Lancashire Gardens Trust
Conservation & Planning Group

6 July 2026

Planning Application No: 3/2026/0356; Erection of 77No dwellings and creation of community parkland with vehicular access from Whalley Road and associated infrastructure parking and landscaping; Land at Hammond Ground, Whalley Road, Read, BB12 7RP.

Figure 6

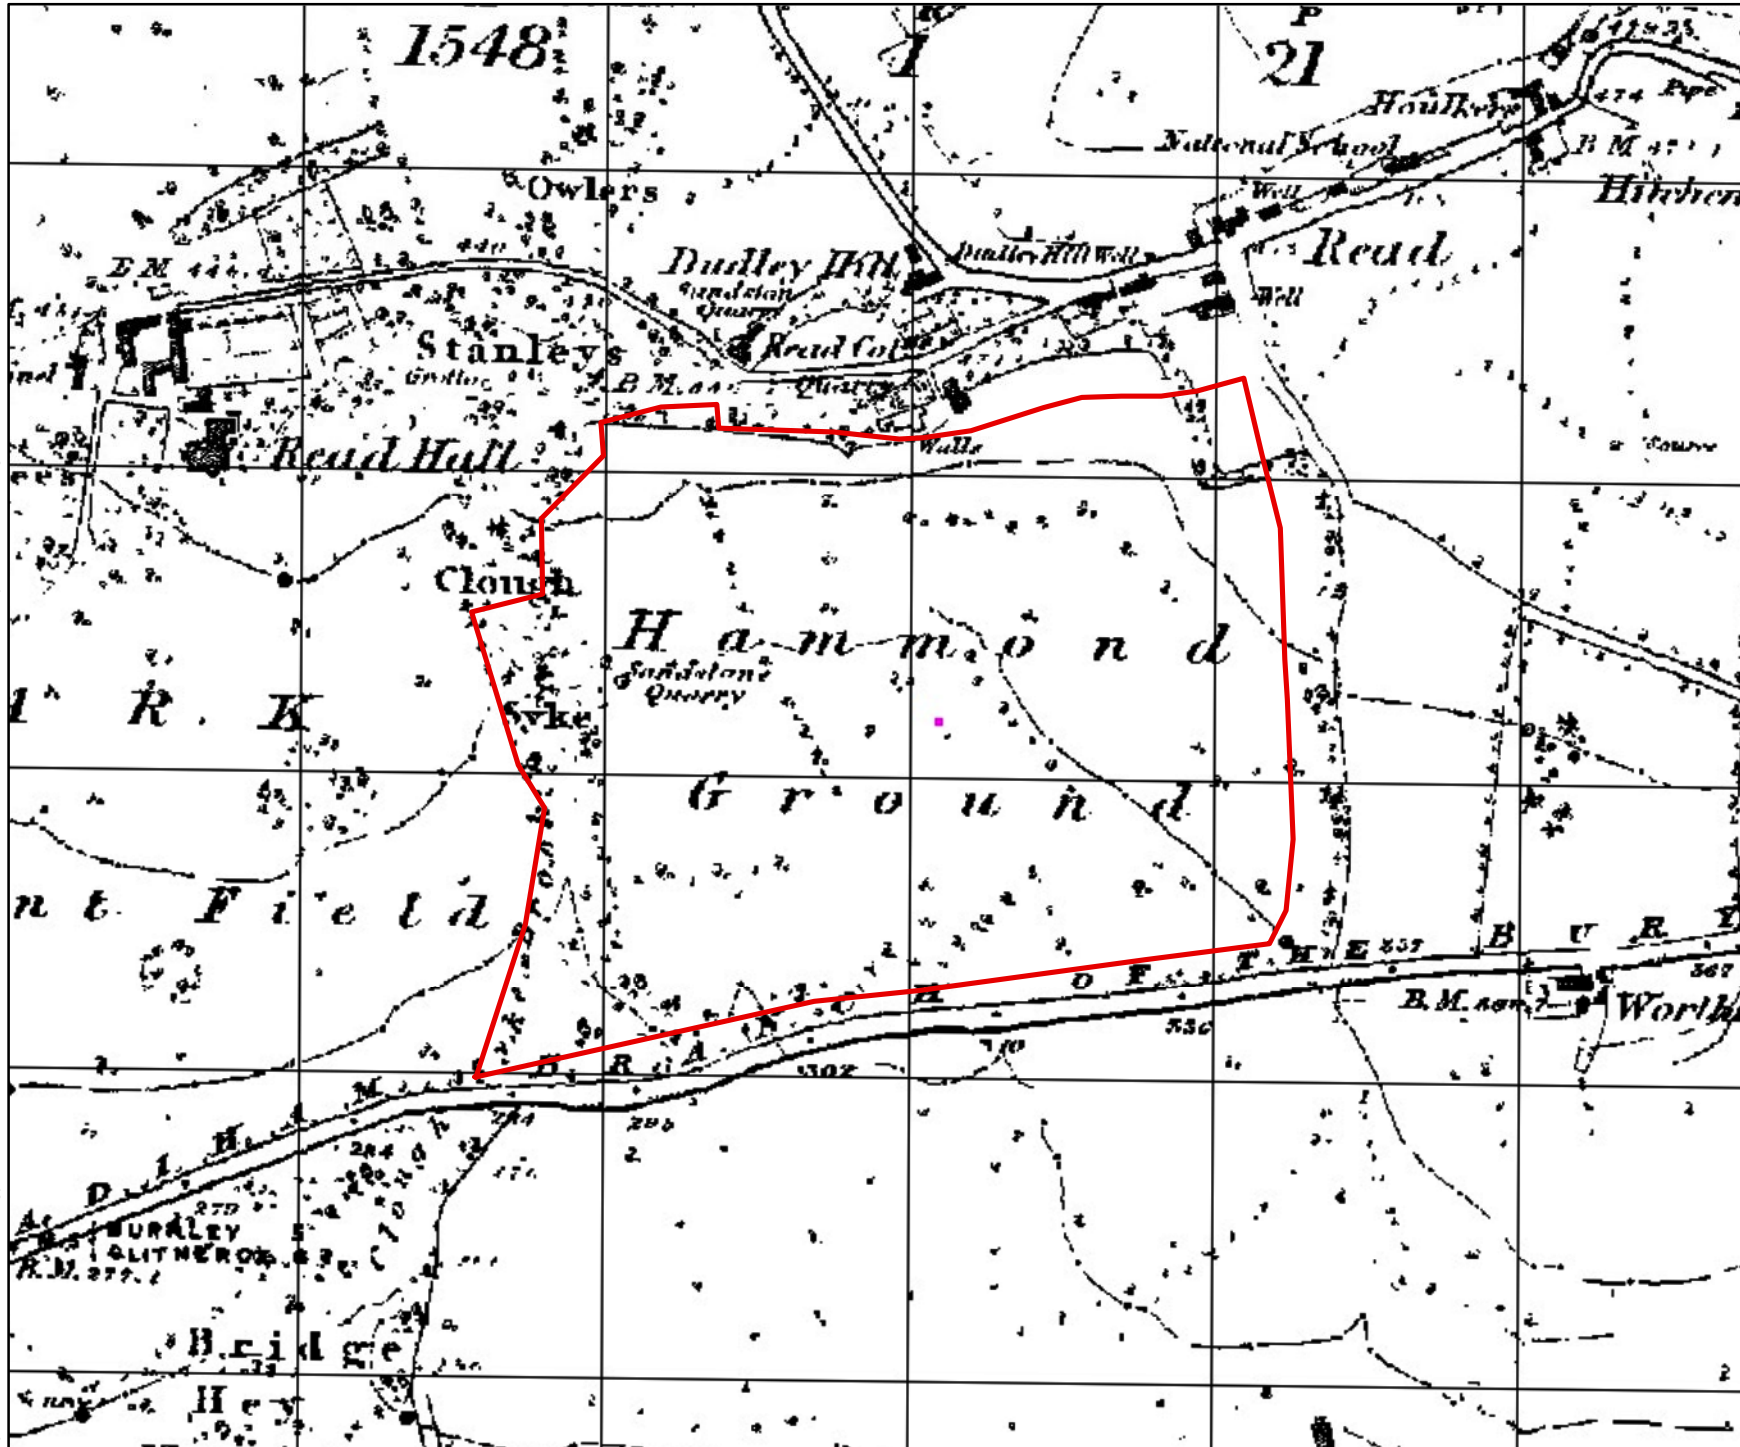
It is worth noting that in Figure 6 the Hennet Map is reproduced which shows Read Park coloured green. The 'approximate' position of the red site outline is incorrectly shown located to the east of its true position, so that it partly lies outside the green area. By studying the alignment of nearby lanes it is clear that the green area includes Hammond Ground, and the red polygon requires correcting to align with the green area.

Figure 7

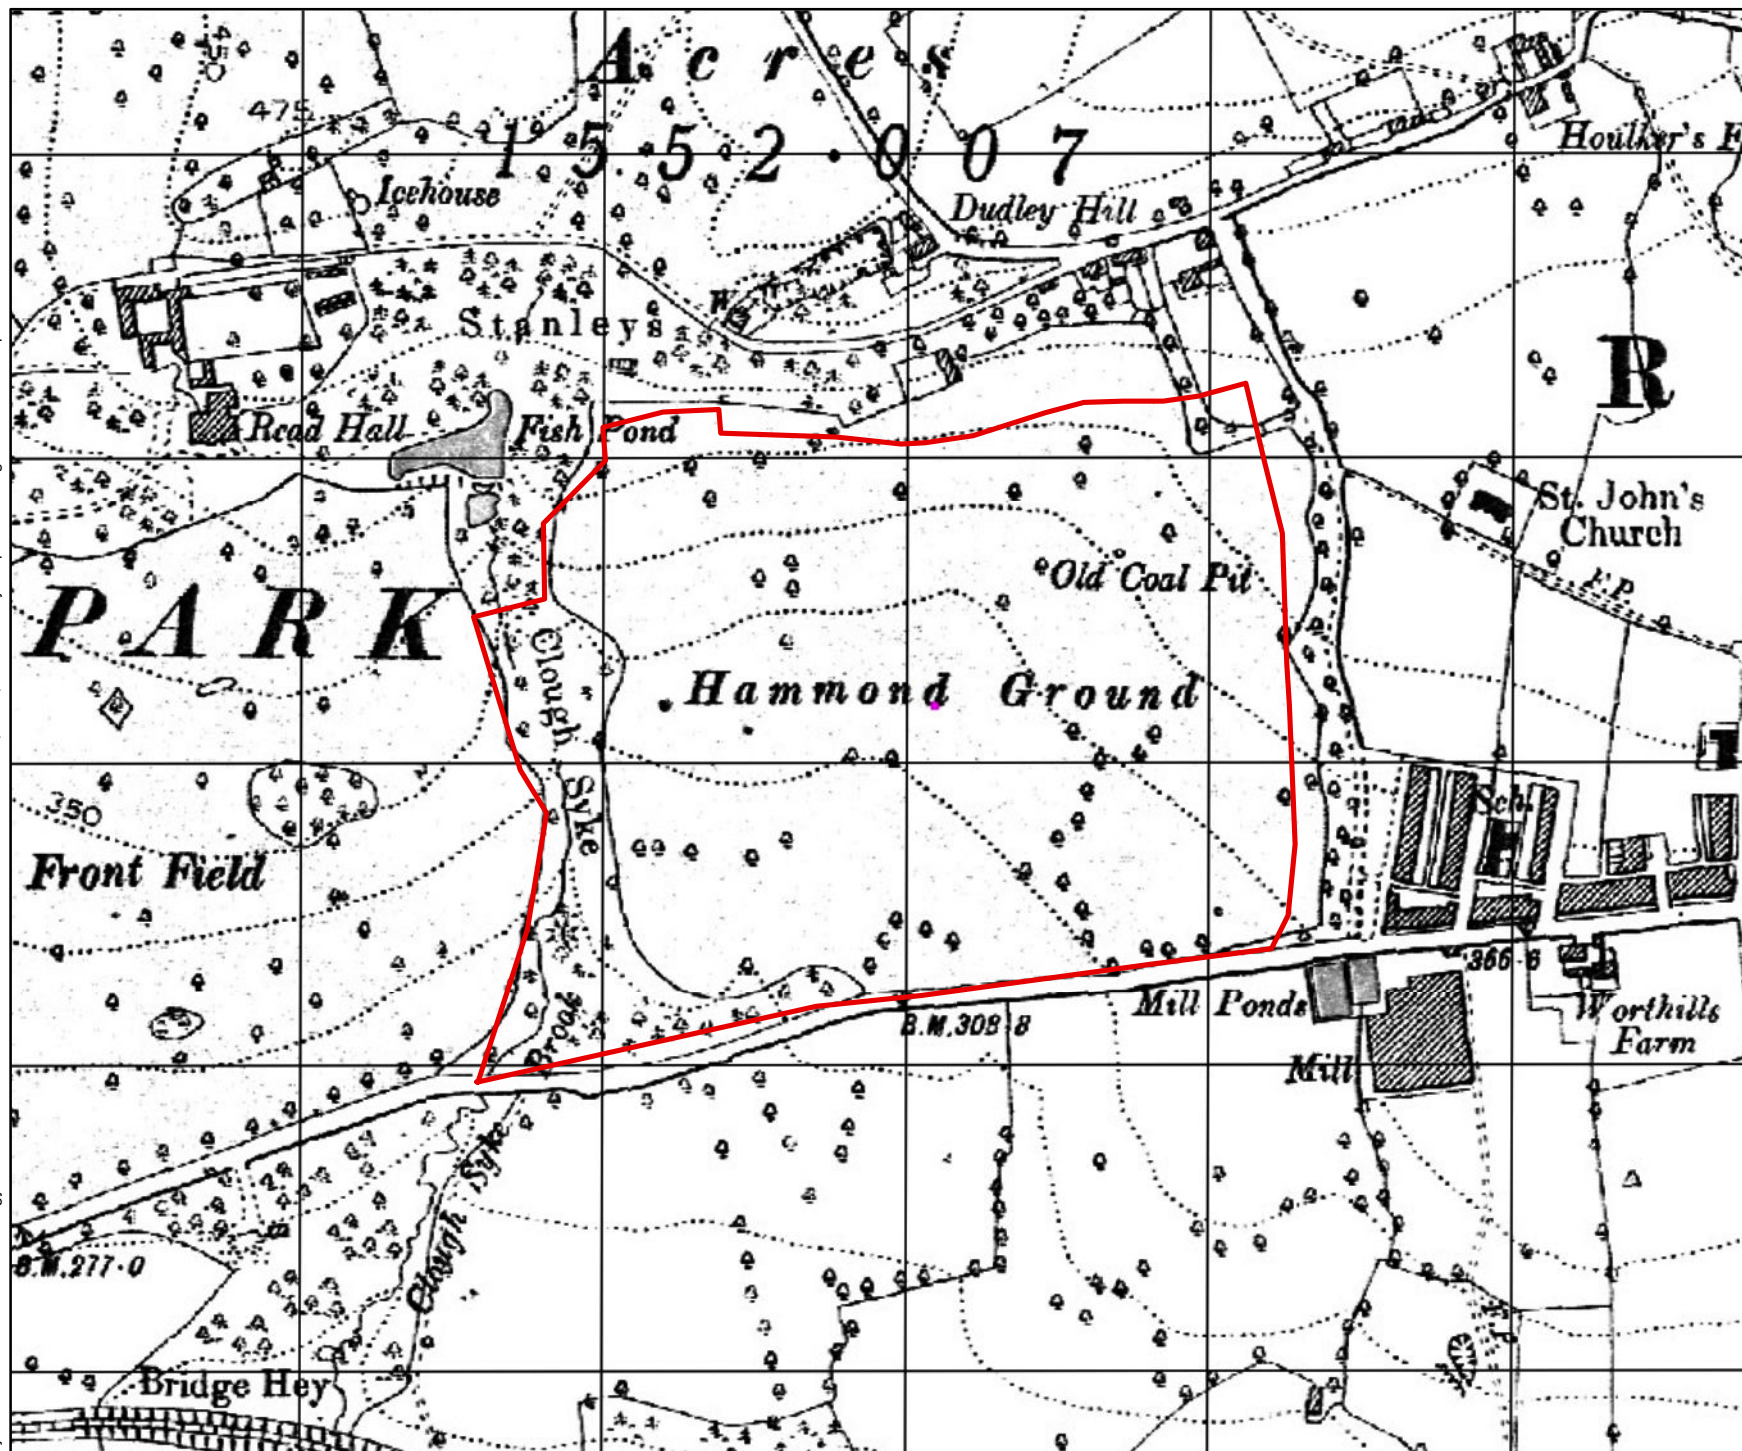
Reference has already been made above of the poor resolution of the OS maps comprising Figures 7 and 8 where the parkland dense dotted shading is not evident. The MARIO maps show the shading in high quality. This OS notation is used to indicate 'Parks and Ornamental Ground' as described in the OS Characteristic Sheet for Six Inch Engraved Maps. This shading is shown on OS maps of 1890s, and also 1912 and 1932, (although these latter two are not included in the Statement Appendix). The title of Figure 8 is of added concern as this is a completely different edition and shows lesser detail to that for 1890s available on MARIO. Perhaps Figure 8 is a later edition and is mistitled? A considerably more legible image using this 1890s base map is available at Figure 5 in the Geophysical Survey Report.
